84 Swallowfield Way, Hayes

Response to London Borough of Hillingdon and Transport for London Comments

N03/226977

August 2023

**Figure 4.1: Pedestrian and Cycle Routes within the Site**

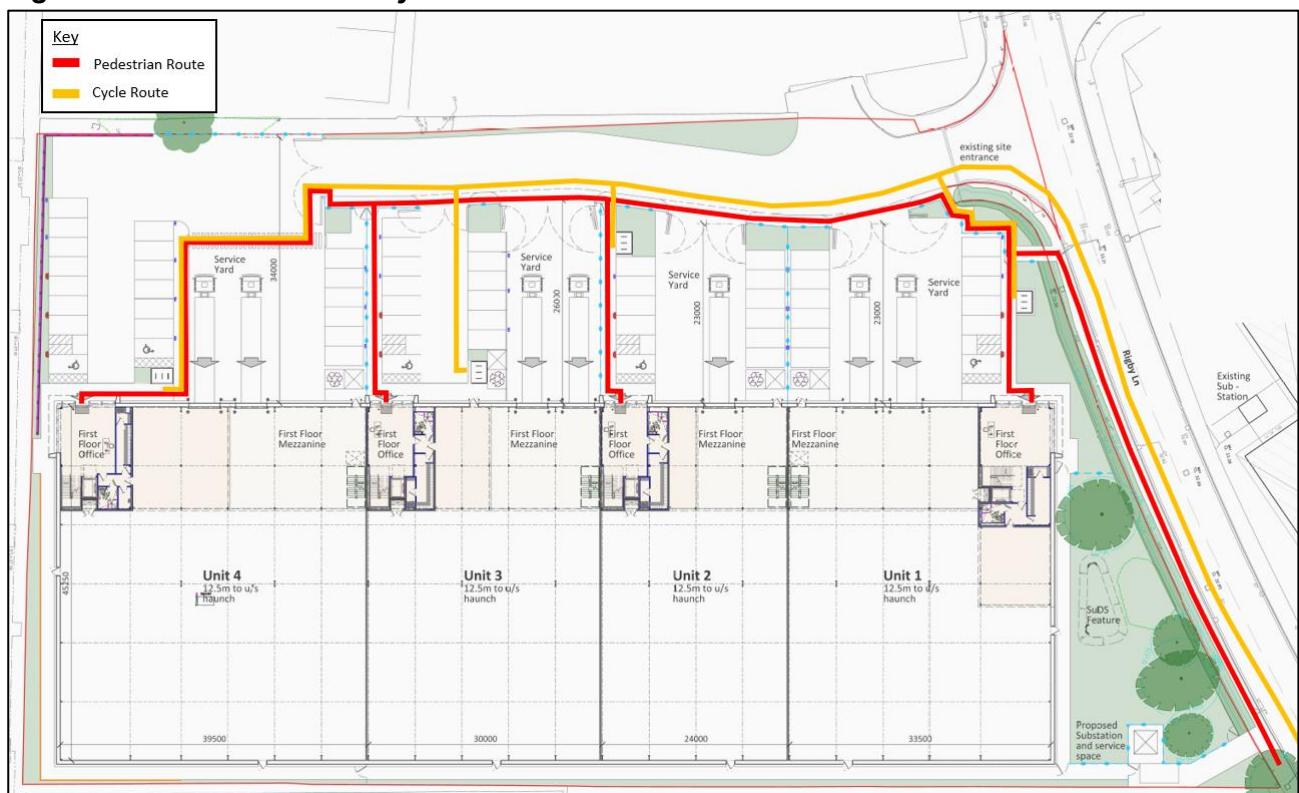
“The Highway Authority believes for the development to provide more safe and convenient access for pedestrians on-site that zebra crossings should be created at the front of each service yard for units 1-3.”

“The Highway Authority would strongly recommend that a segregated cycle lane into the site is provided for cyclists, as this will support active modes of travel to the site and meet the Healthy Streets Approach”

16. The site plan has been updated based on comments received from TfL and LBH. The updates include the provision of zebra crossings at the front of each service yard for units 1-3.
17. With regard to cycling, it is proposed that a dropped kerb will be provided at the pedestrian access and a sign indicating to cyclists to dismount and walk their bikes to the cycle parking. Additional signage will also be provided at the vehicular access warning drivers of the potential presence of pedestrians and people walking their bikes in the area. These improvements are illustrated on the drawing provided within **Appendix A**.

DRAWING NUMBER: 226977/AT/D01 REVISION: F

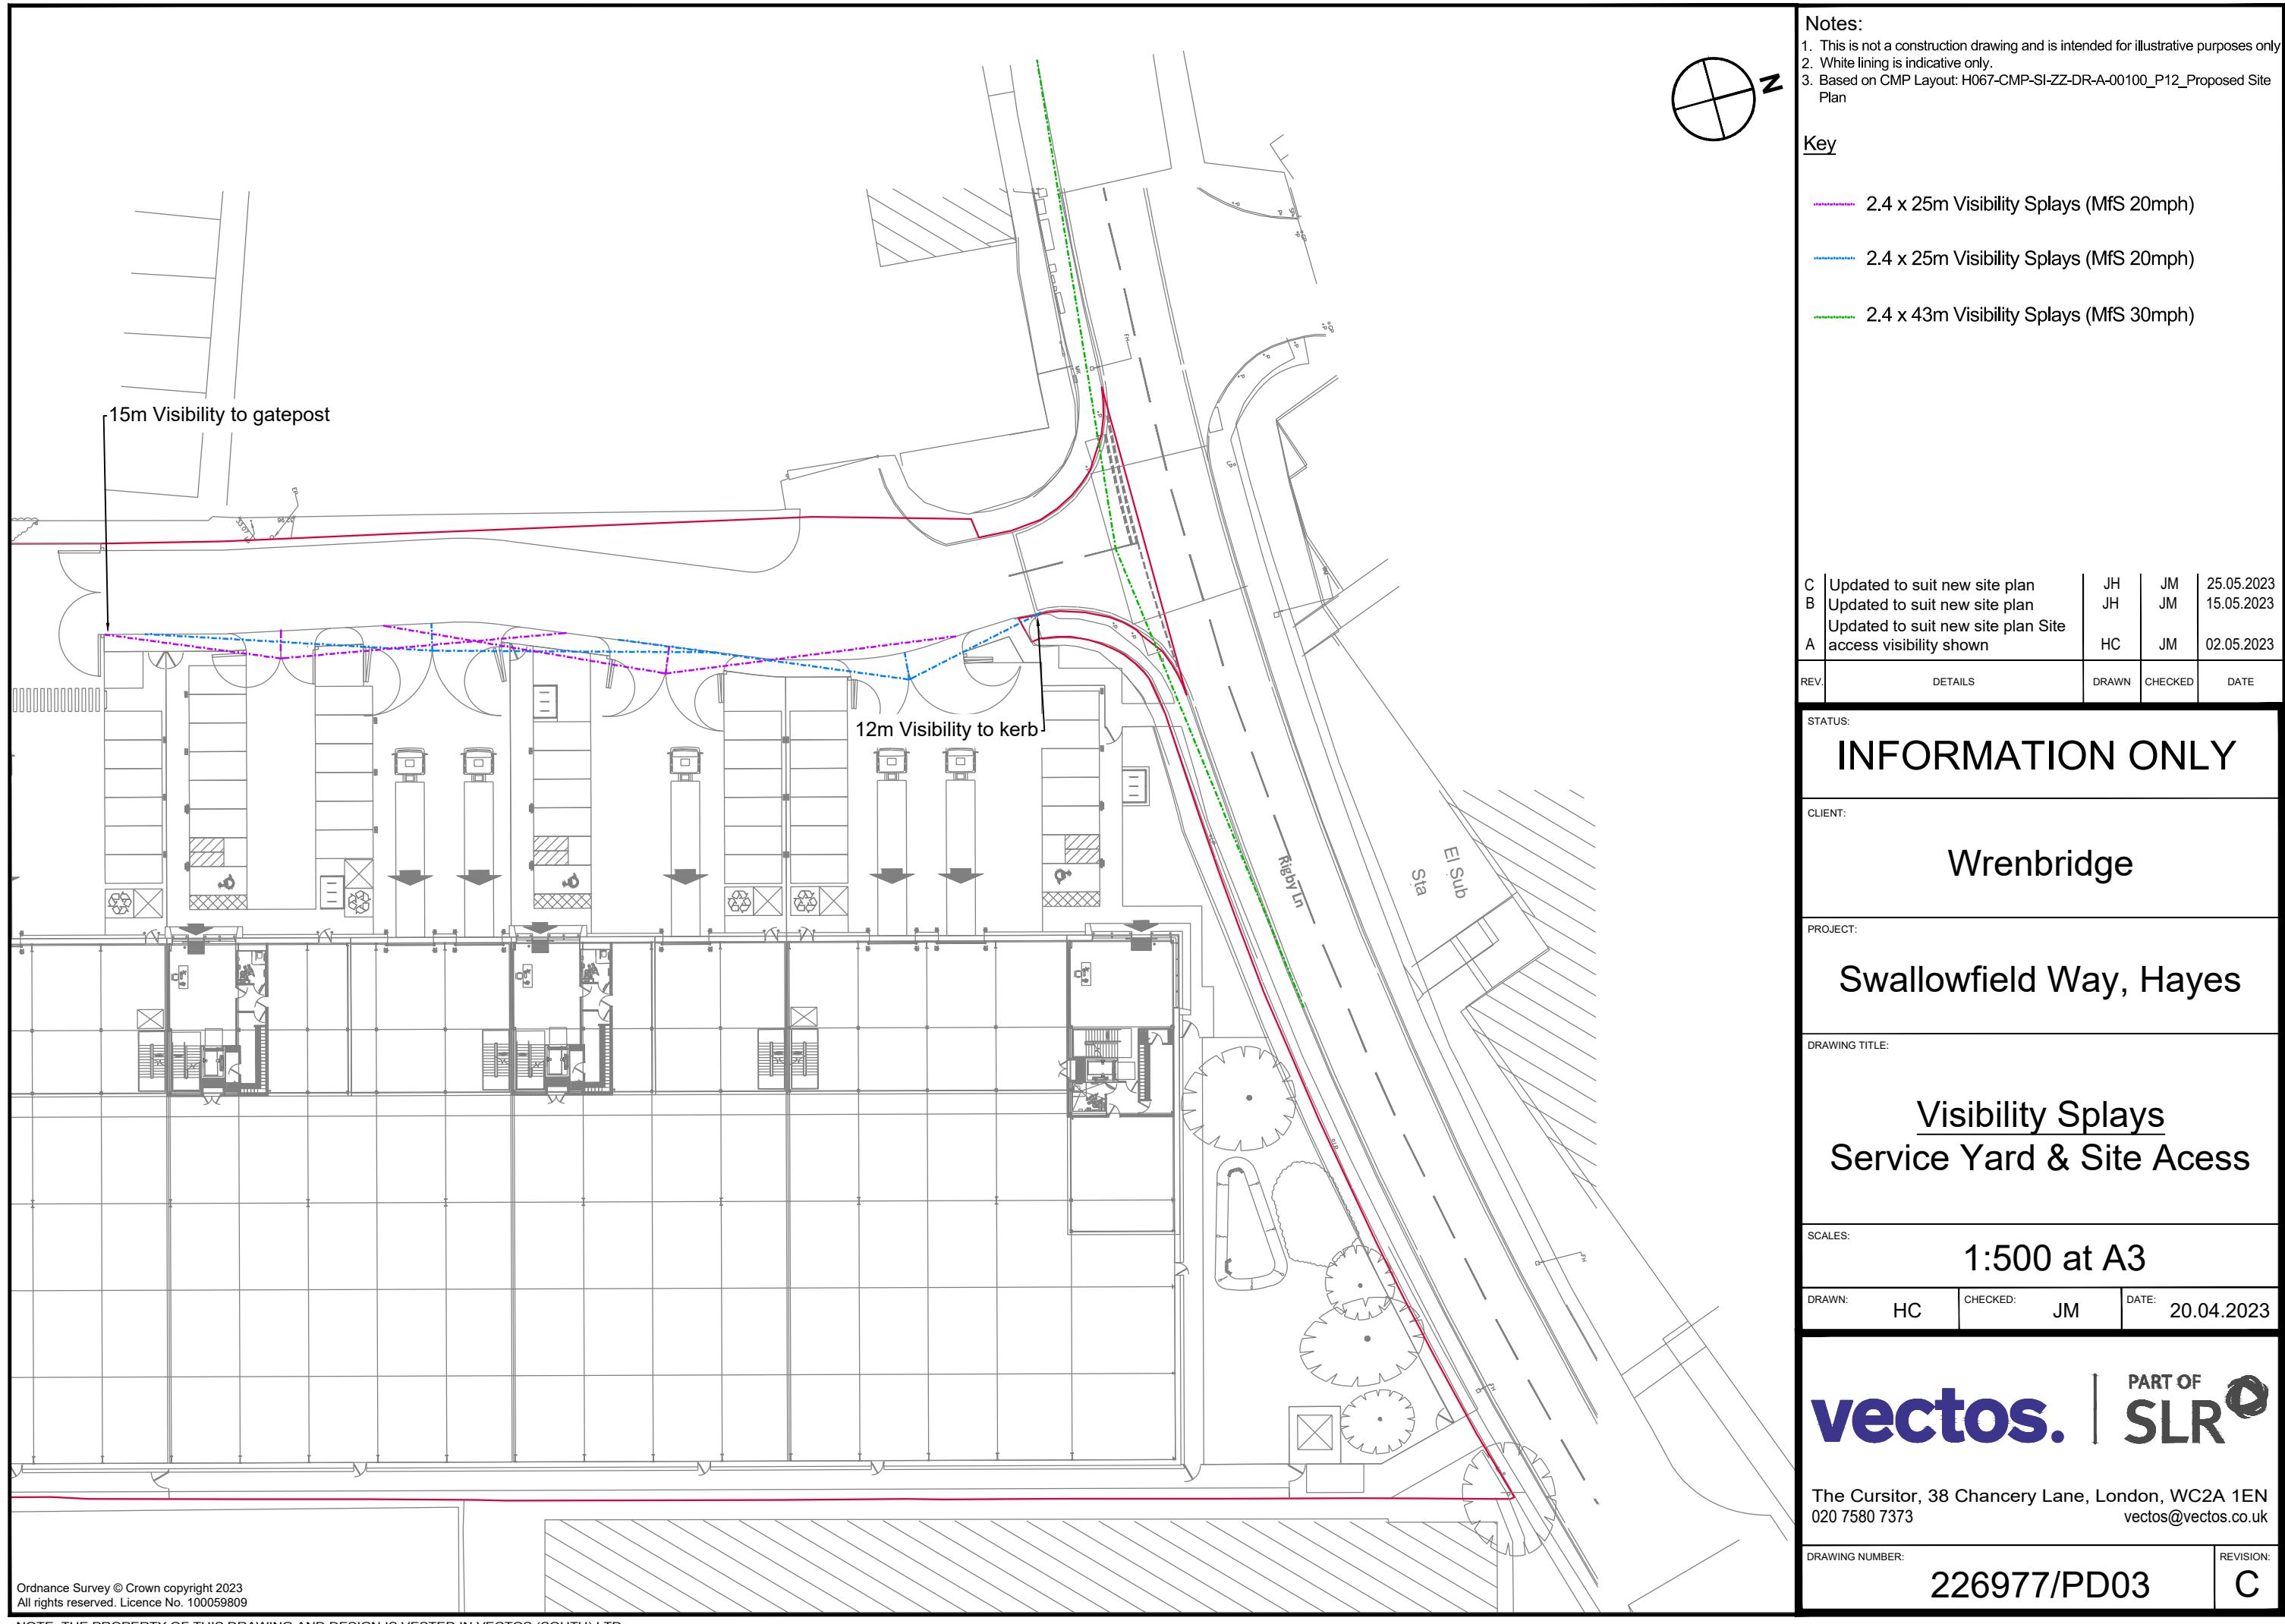
“[It] needs to be demonstrated that two goods vehicles will be able to pass safely without potential collision as there are serious concerns from TfL that the site is constrained with the high level of vehicular parking currently proposed.”

“There is also a concern that vehicles could queue back onto the adjoining highway network, therefore impacting road safety contrary to Policy T4.”

33. The HGV traffic profile in **Table 2** shows the maximum expected number of two-way movements per hour is 9. This is the equivalent of an arrival or departure every 6 minutes, as such the frequency of HGVs having to give-way to one another is likely to be minimal. In terms of opposing flows, 5 HGV

- arrivals an hour equates to an HGV arrival every 12 minutes, and 4 HGV departures an hour equates to an HGV departure every 15 minutes. On the basis each HGV manoeuvre takes about 10–15 seconds, the probability of conflicting HGV movements occurring at the same time is very low. This remains the case even allowing for the HGV movements to and from the adjoining site, which the survey demonstrates generates a maximum of 1 HGV arrival and 1 HGV departure in any one hour.

34. On the basis of a maximum of 11 HGV movements per hour at the site access and 10–15 seconds per manoeuvre, demonstrates that the site access – at its busiest - will only be in use for HGV movements for 165 seconds per hour, or circa 5% of the time.

35. In addition, and as already mentioned, priority will be given to HGVs accessing the site and banksmen will be on duty within the service yards.
 36. Furthermore, with a maximum of 5 HGVs onsite at any one time (assuming the maximum number of arrivals in anyone hour are all on site at the same time), and 7 HGV loading bays on-site, it is considered that there would not be a series of HGVs waiting for a free loading bay.
